**RE: Crows Nest Over Station Development Site B (SSD-614000212)
Response to Submissions and Additional Information**

This statement summarises Stantec's response to the submissions.

Sheet title  
CARPARK LEVEL 05

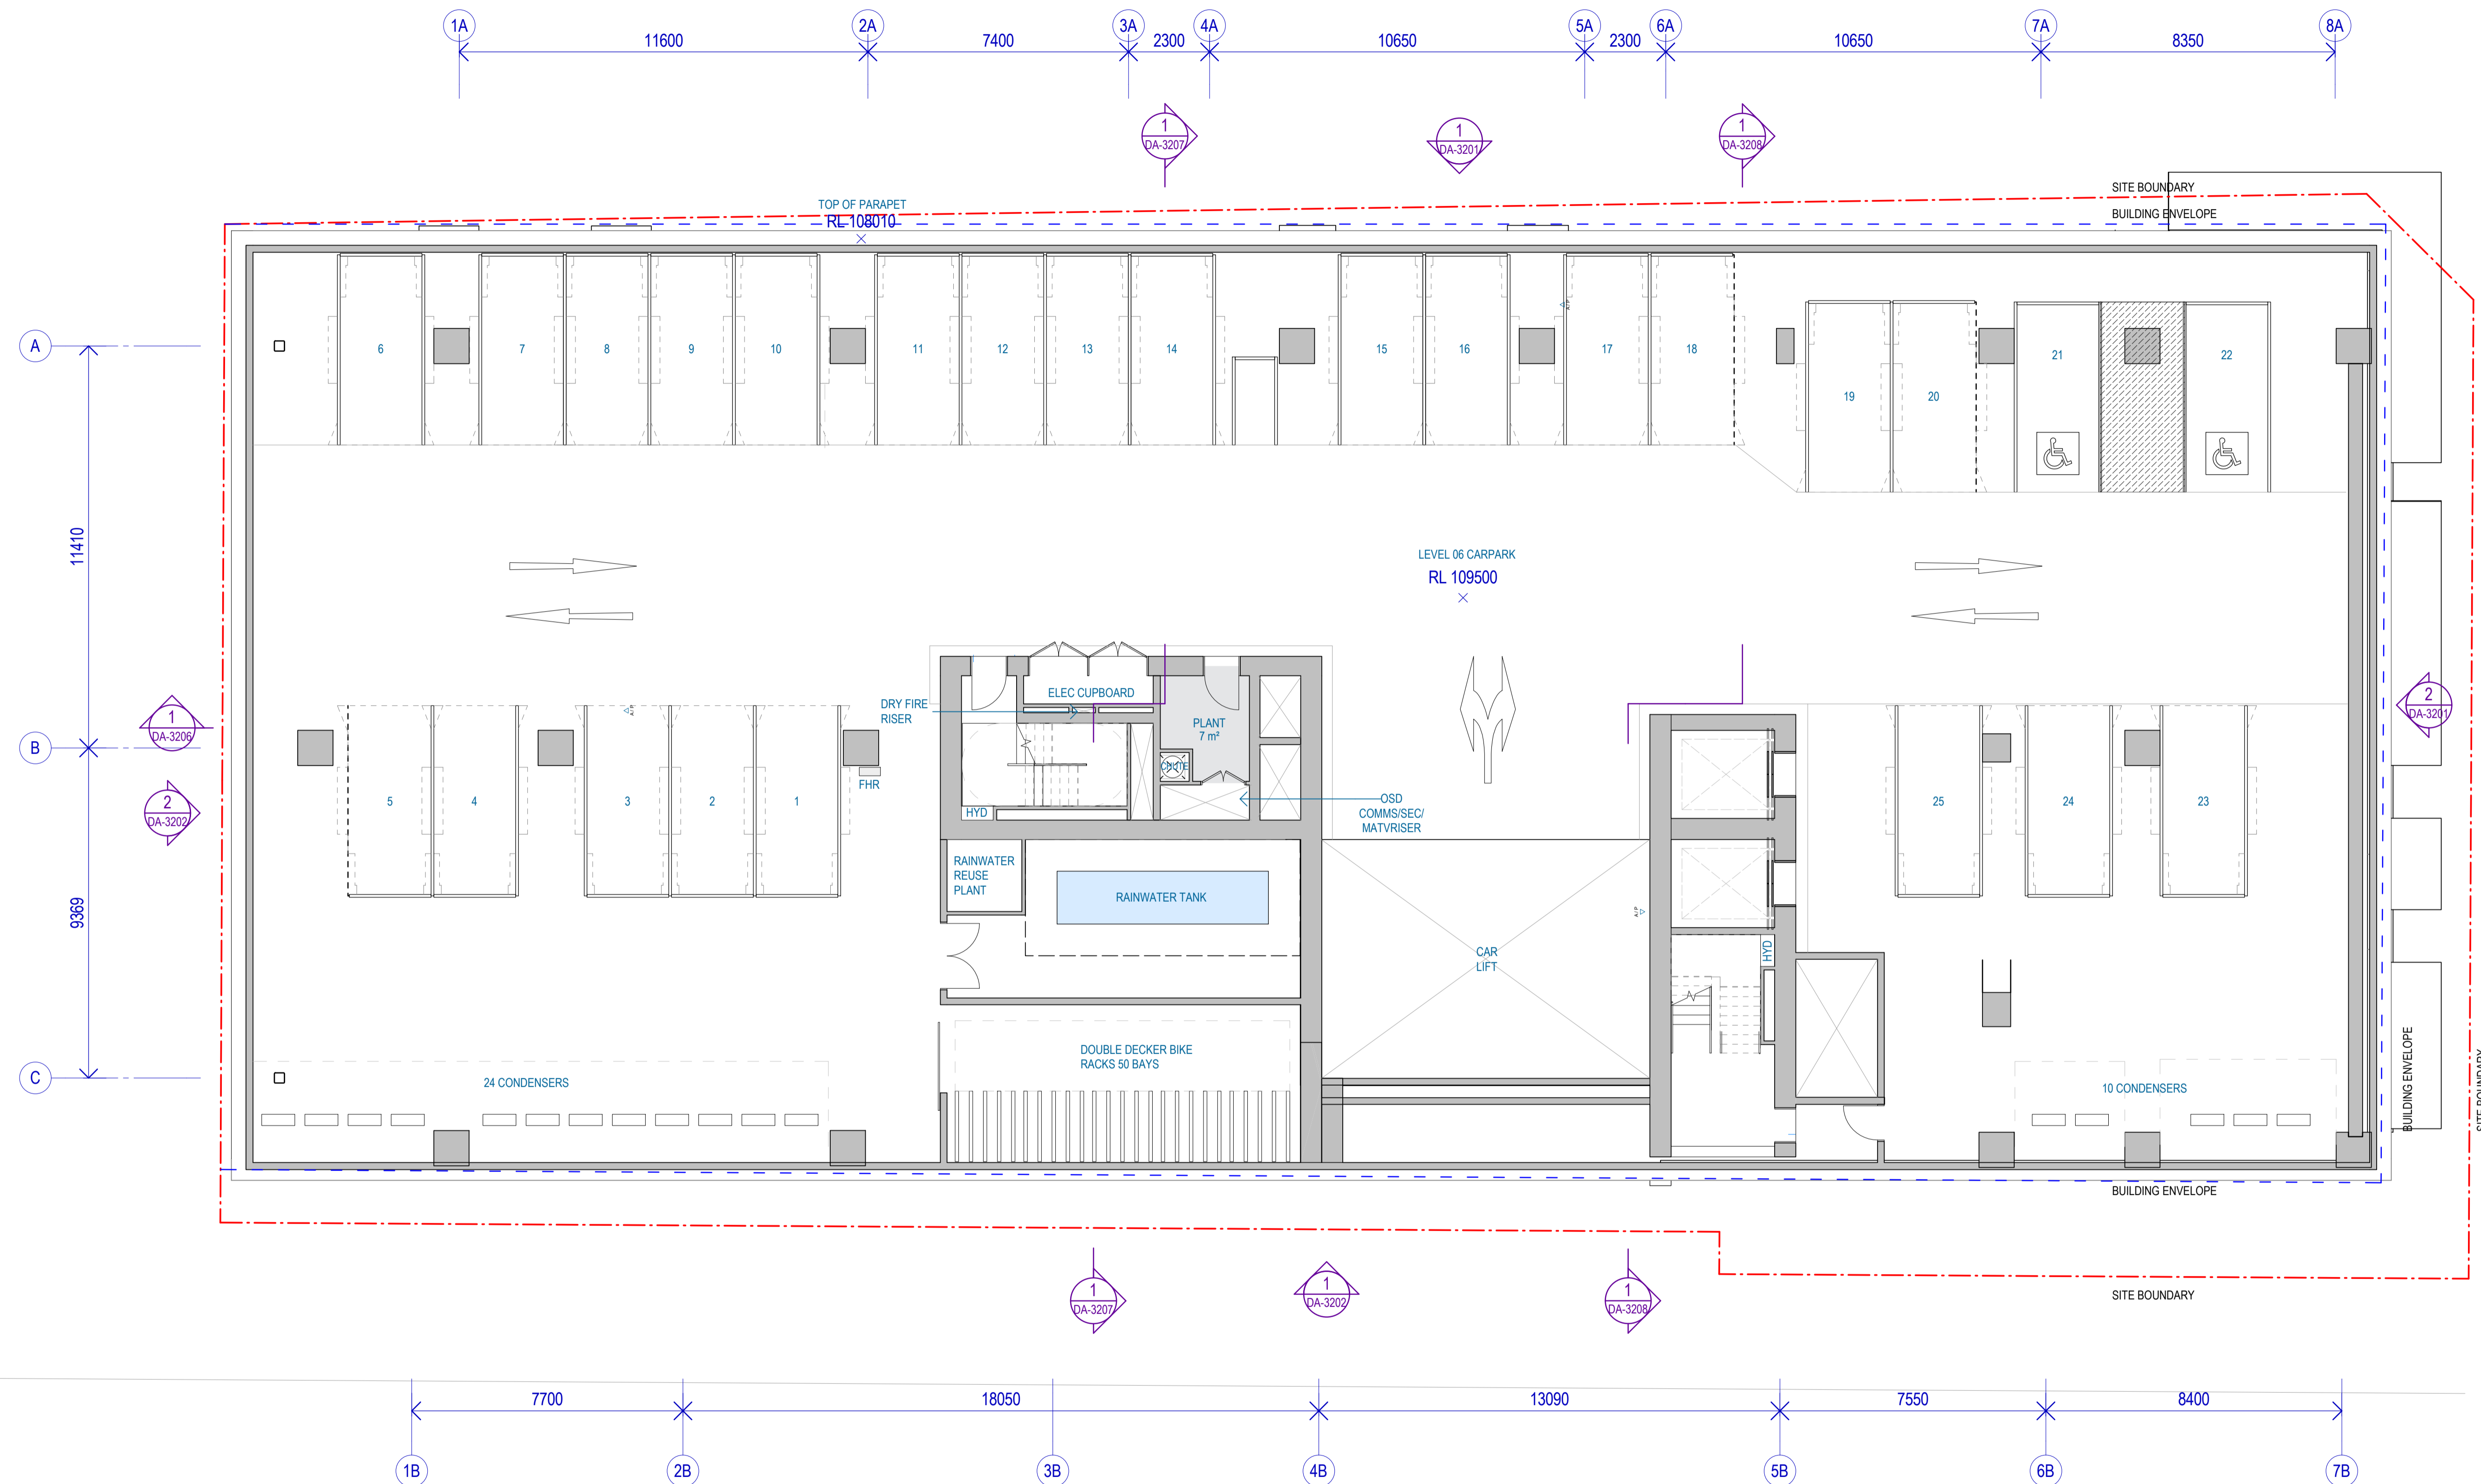
In general, the accessible spaces have been designed in accordance with the requirements of AS2890.6:2022, however, there are some accessible spaces where there are columns located within areas of the shared bays not permitted by AS2890.6:2022. Specifically, these are Spaces 21 and 22 on Level 5 and Space 21 on Level 6.

Whilst these shared bays are not strictly compliant with AS2890.6:2022, the design of these shared bays are supported through a performance solution provided by the Access Consultant (refer to MGAC Performance Solution Report).
